MECKLENBURG COUNTY

Park and Recreation Department

MEMORANDUM

RE: Rezoning Petition #2025-086
PID # 108-171-11

PENCE ROAD INDUSTRIAL SITE REZONING PLAN (2025-086)

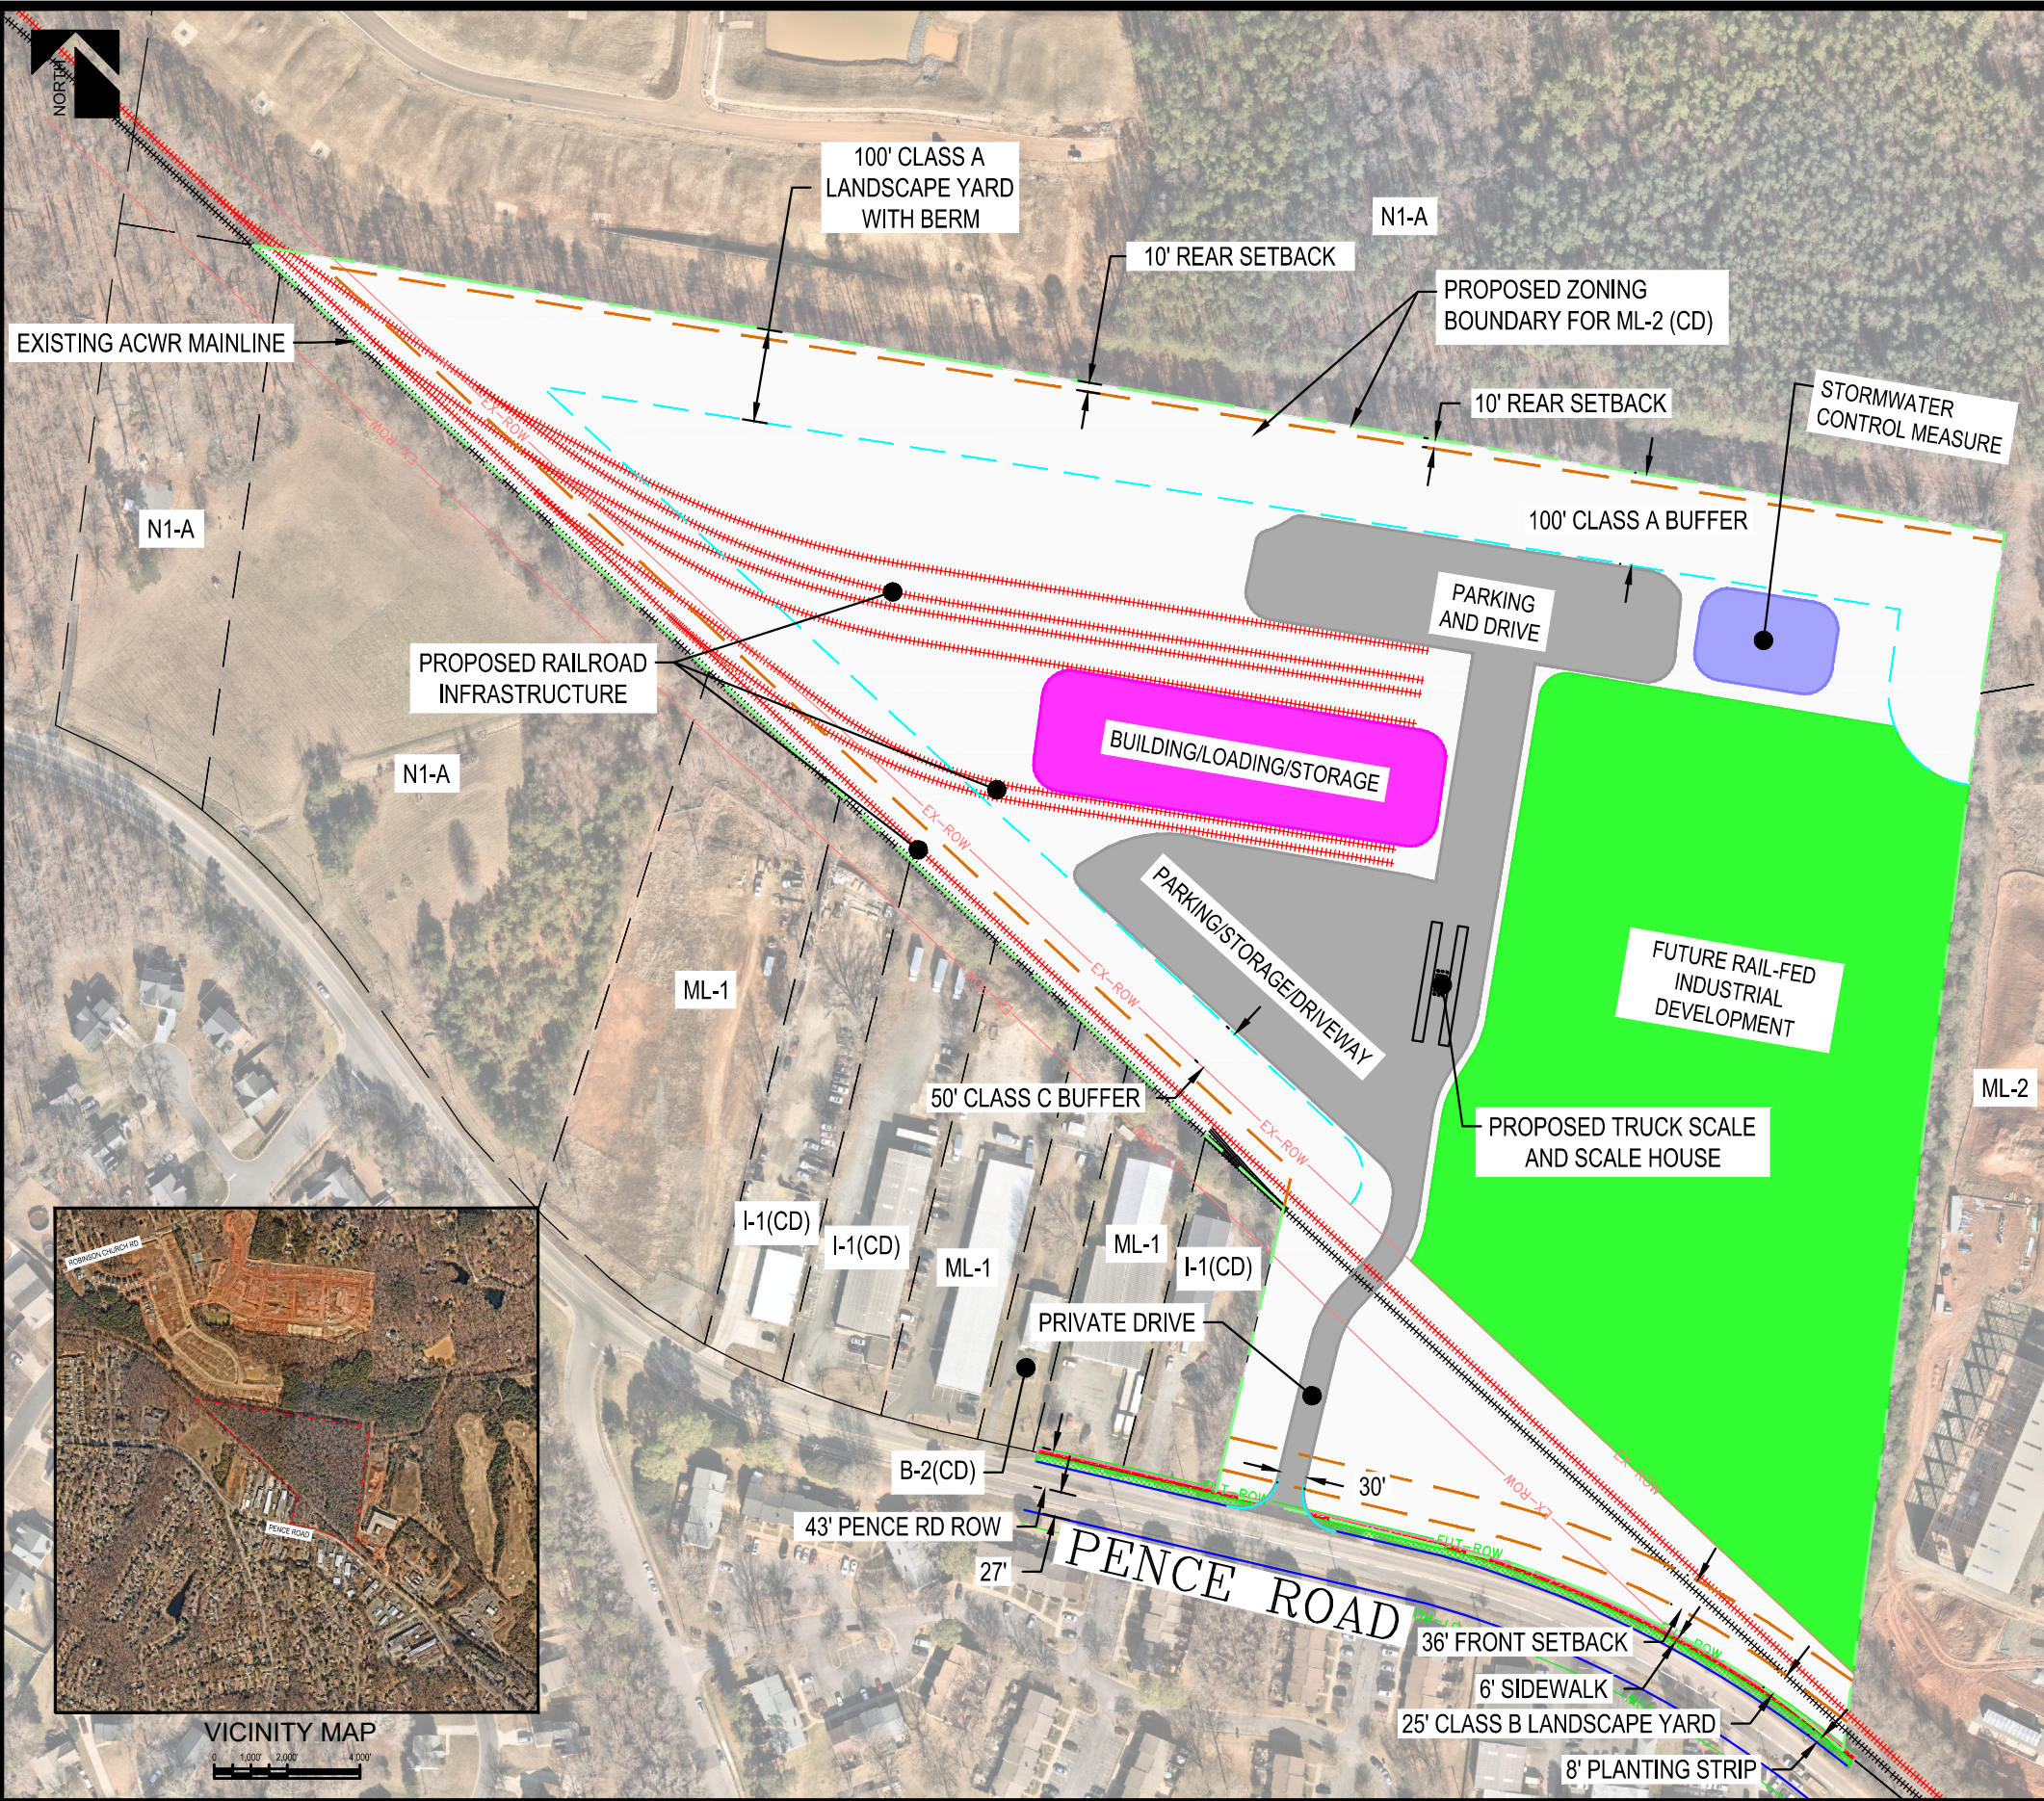
Mecklenburg County requests a minimum of 50' width easement on the southern property boundary which overlaps the existing railroad ROW for future greenway. The notes on the plan should indicate that the easement shall be dedicated and conveyed to Mecklenburg County
